SECTION 75W MODIFICATION APPLICATION LEE WHARF BUILDING C NEWCASTLE

MP 05_0007 (MOD 2)

Modification of Minister's Approval under section 75W
of the *Environmental Planning and Assessment Act*
1979

August 2010

NORTHERN ELEVATION

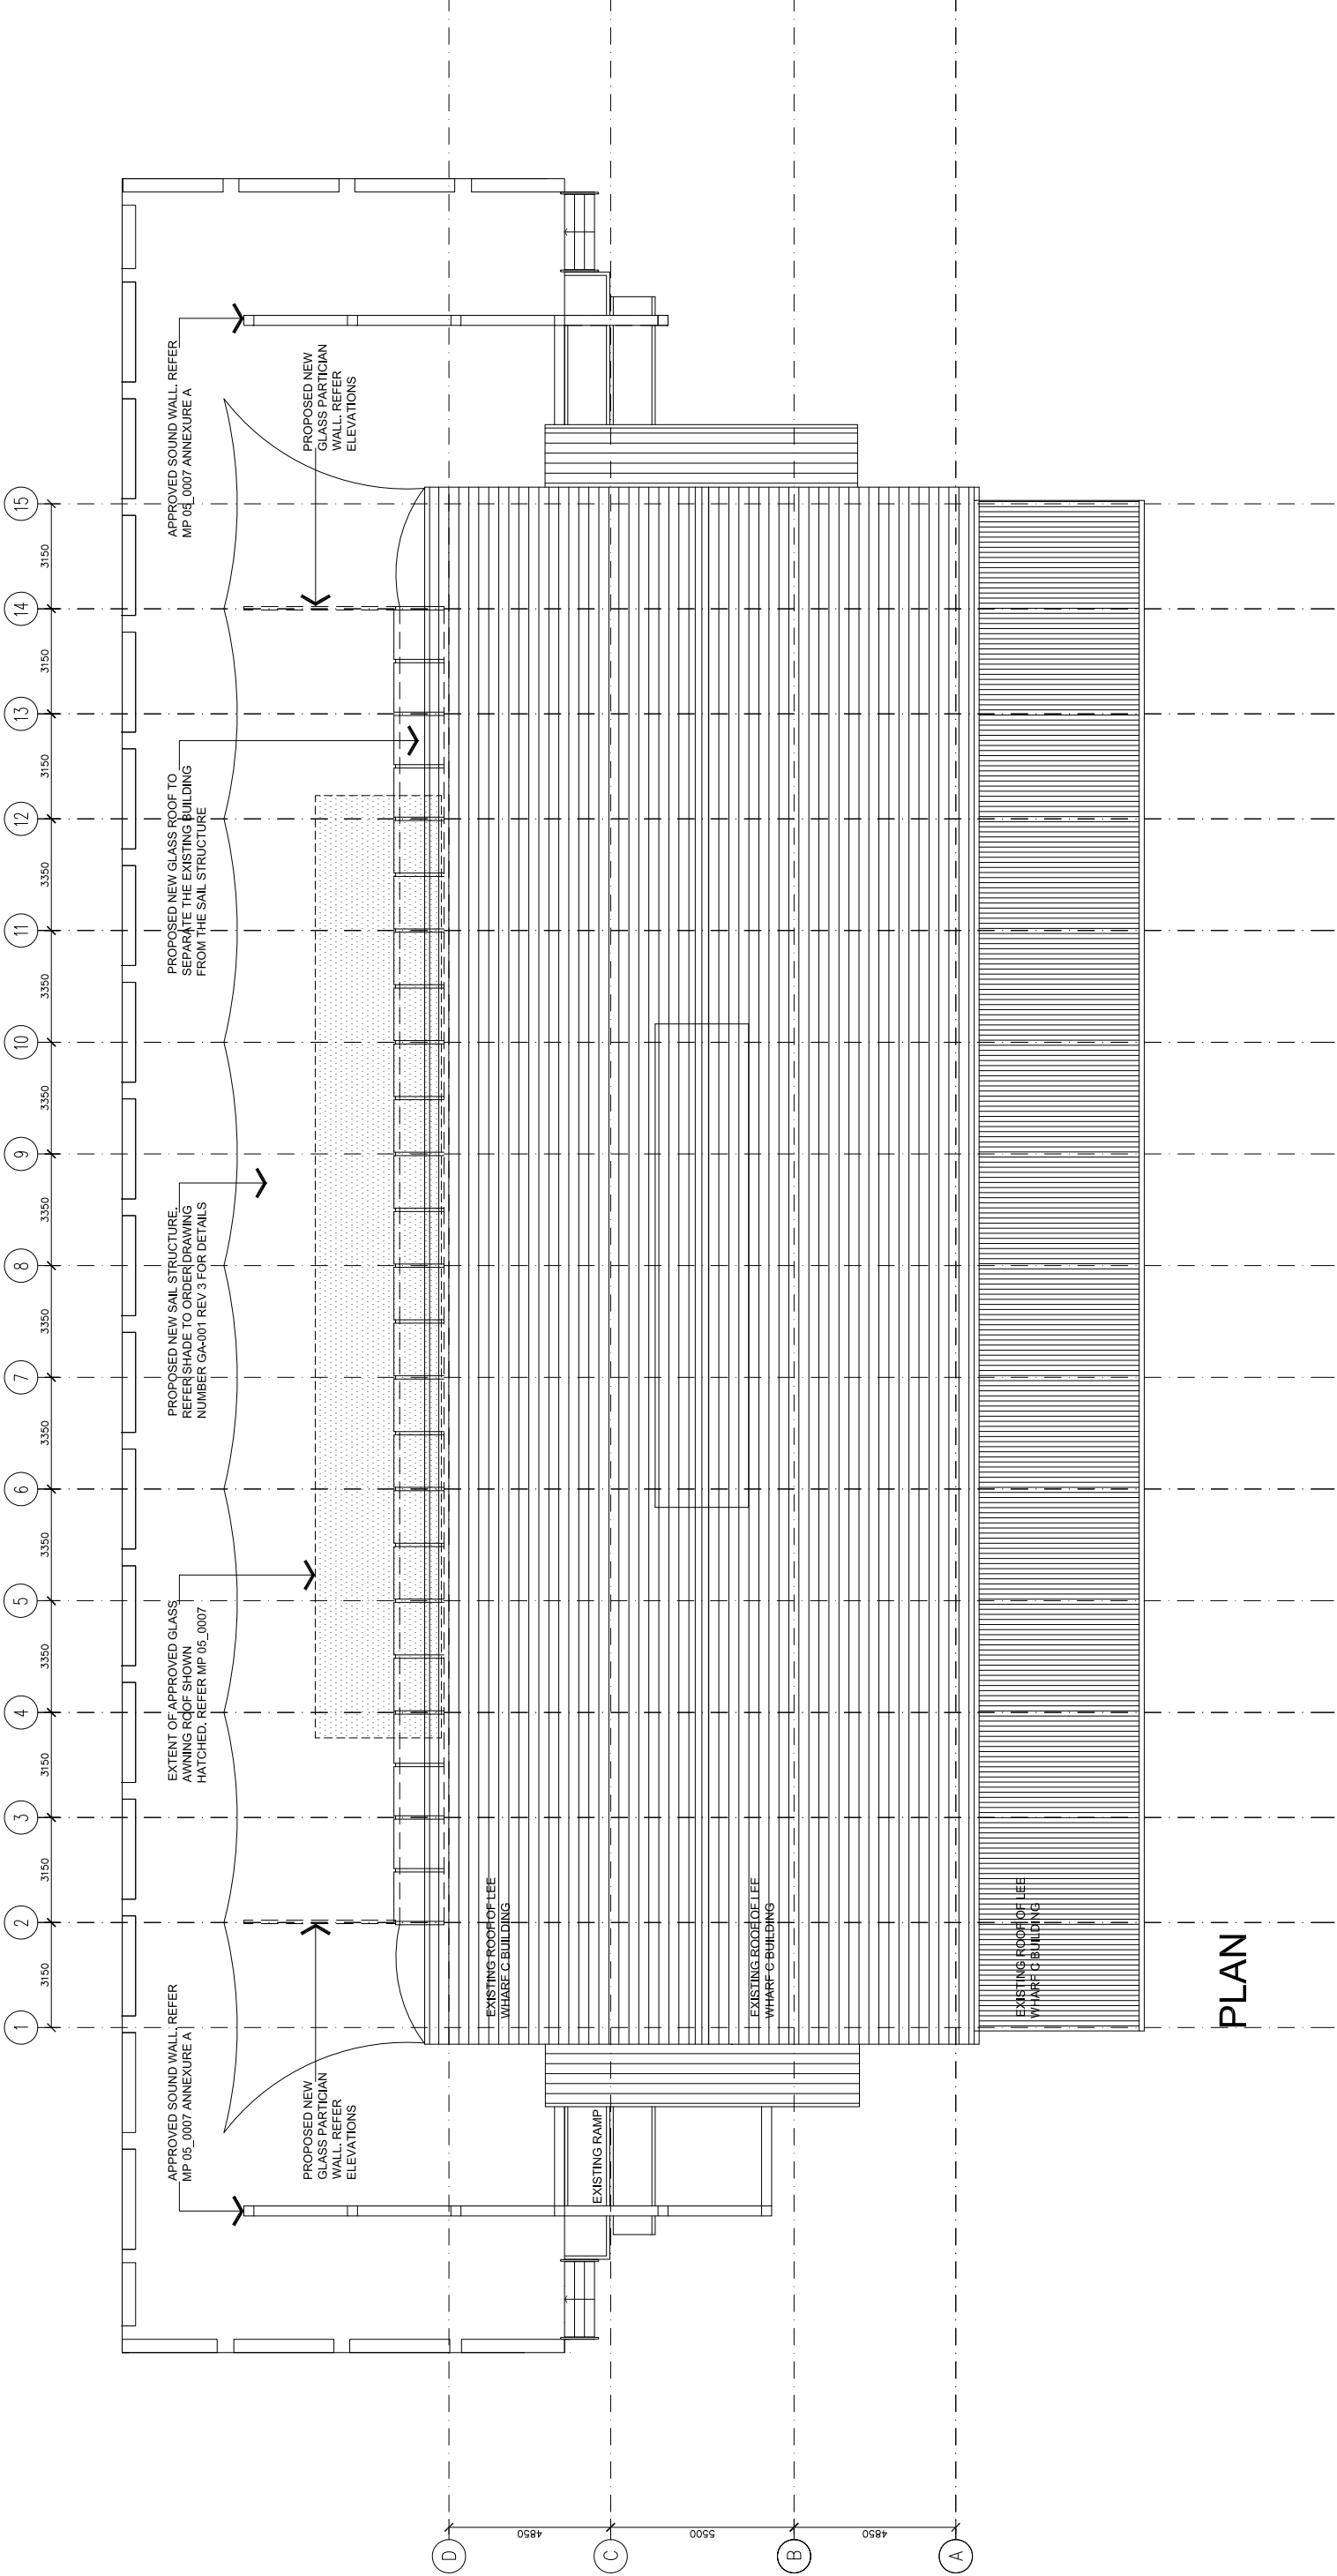
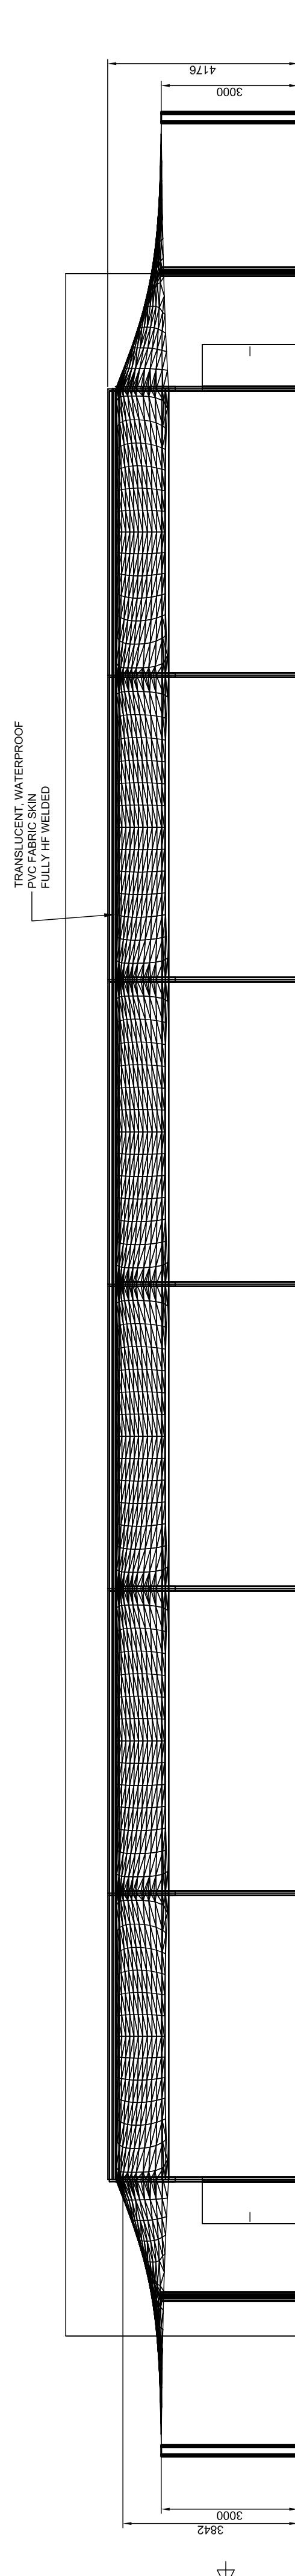
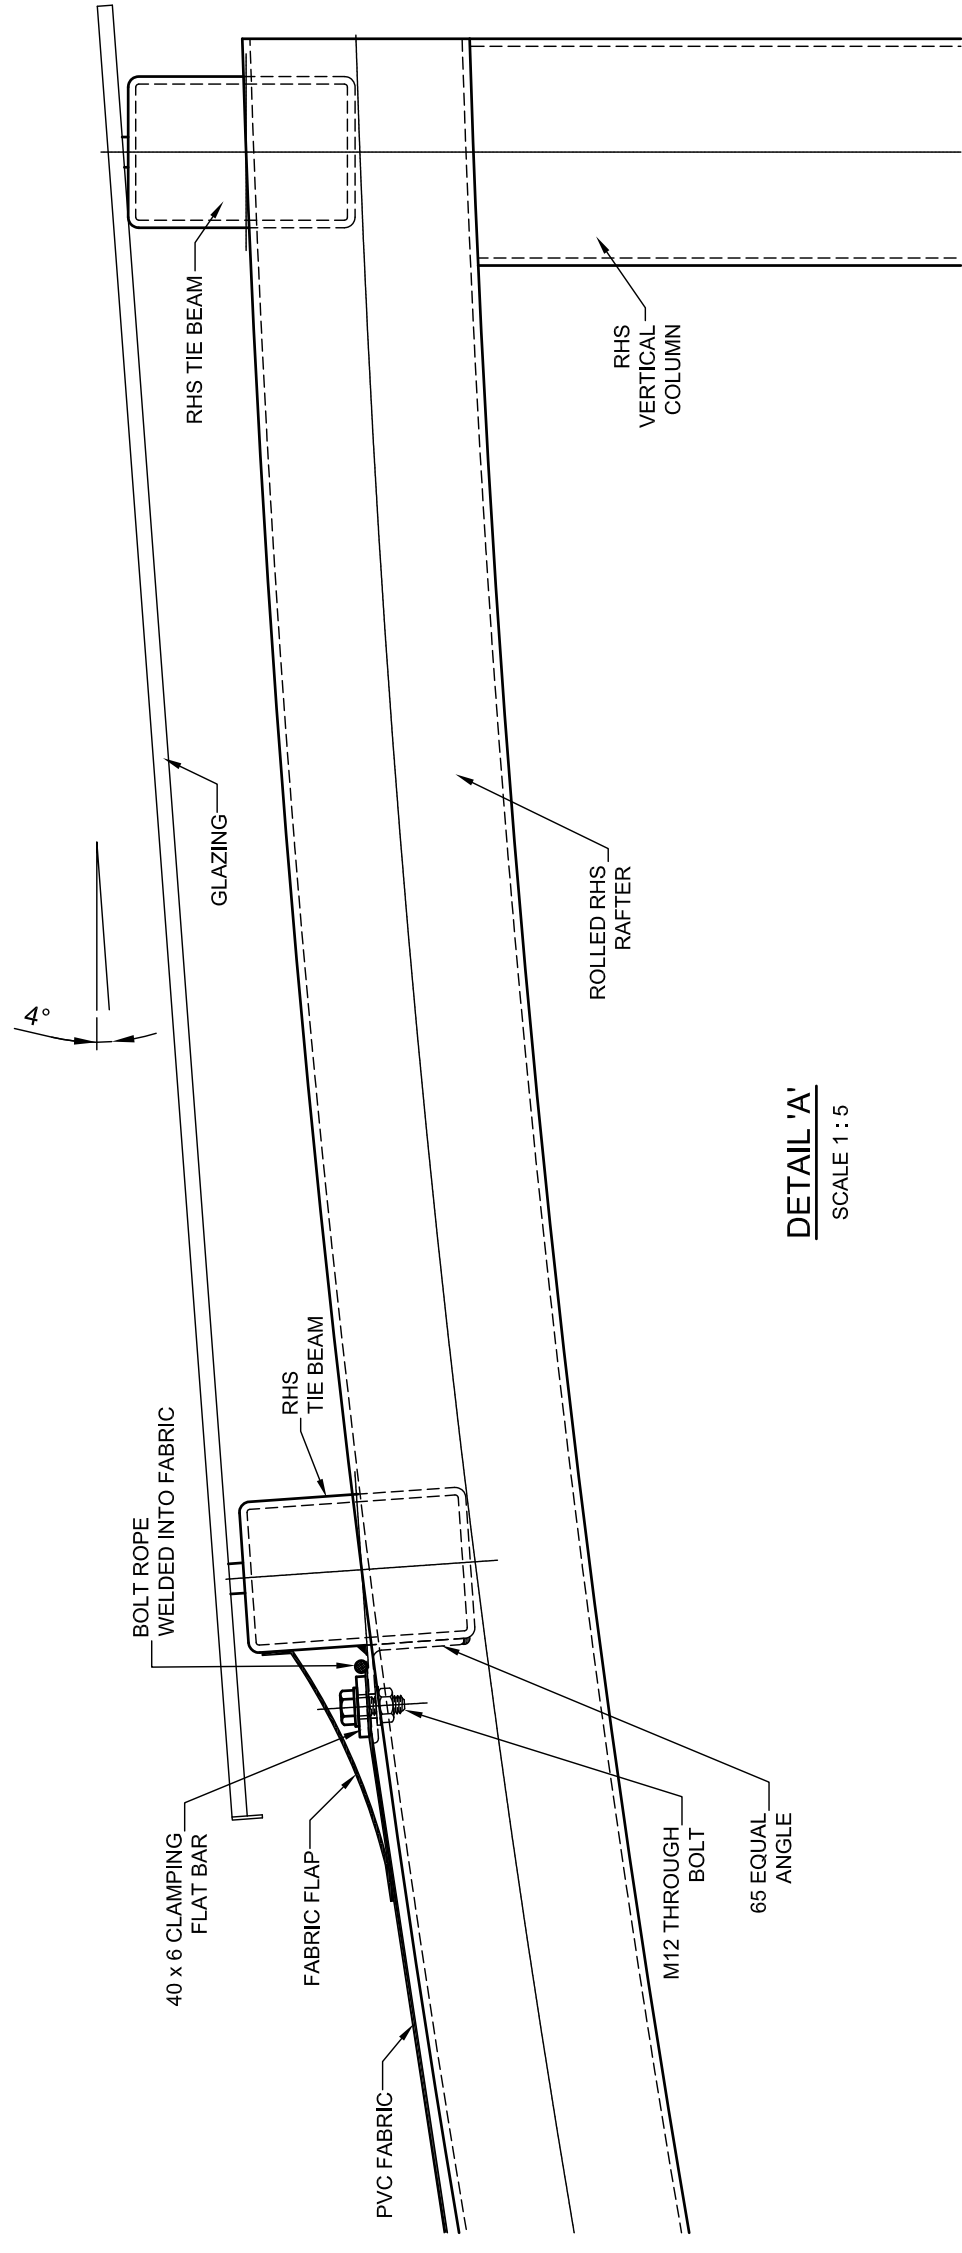
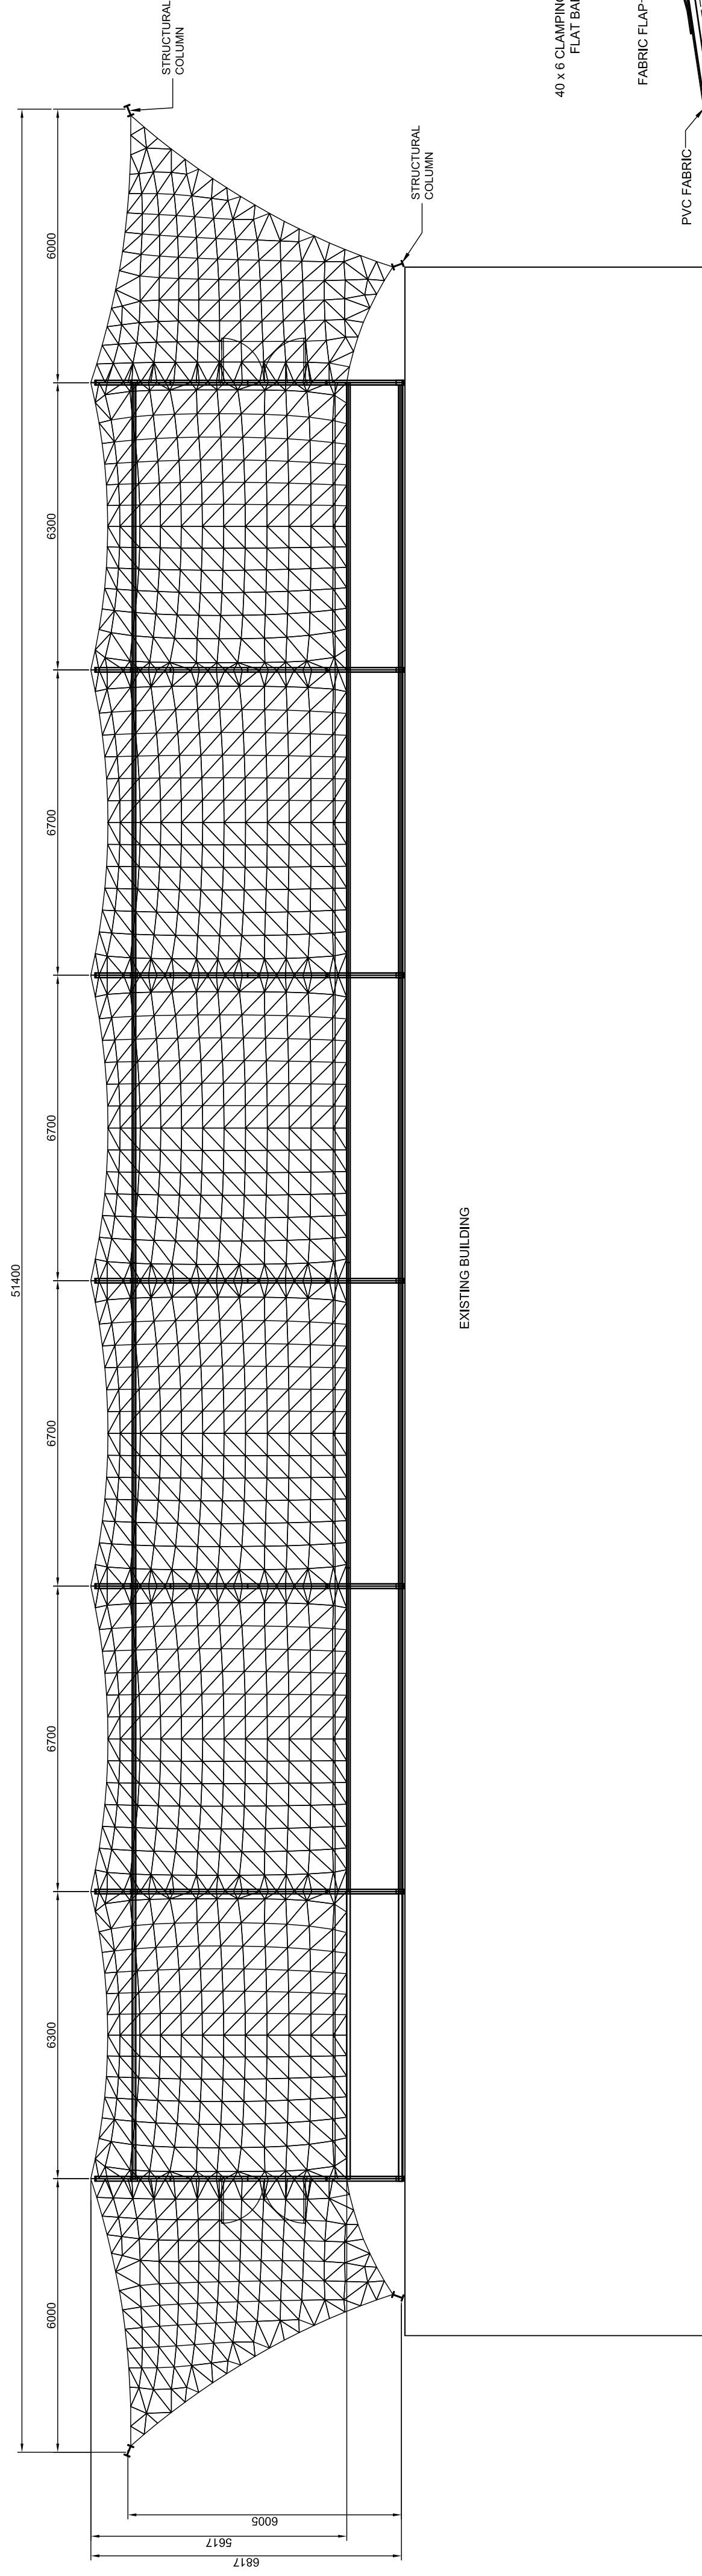
- The sail structure is separated from the building and this is desirable. Certification of the separation should be provided.
- Building is listed as having State Heritage Significance and should be referred to the Heritage Branch of the Department of Planning
- Sound walls should be verified that they will manage noise emissions.

Initially the Heritage Branch raised concerns about the size and scale of the proposal. However, after a site inspection was undertaken by the Branch on the 28 July 2010, the application was supported, subject to a condition being imposed to prevent the enclosure of the awning.

The approved plans illustrate the separation via a glass roof. Application was referred to the Heritage Branch. Sound walls do not form part of the application.

Agree. A condition will be imposed to ensure the awning is not enclosed.
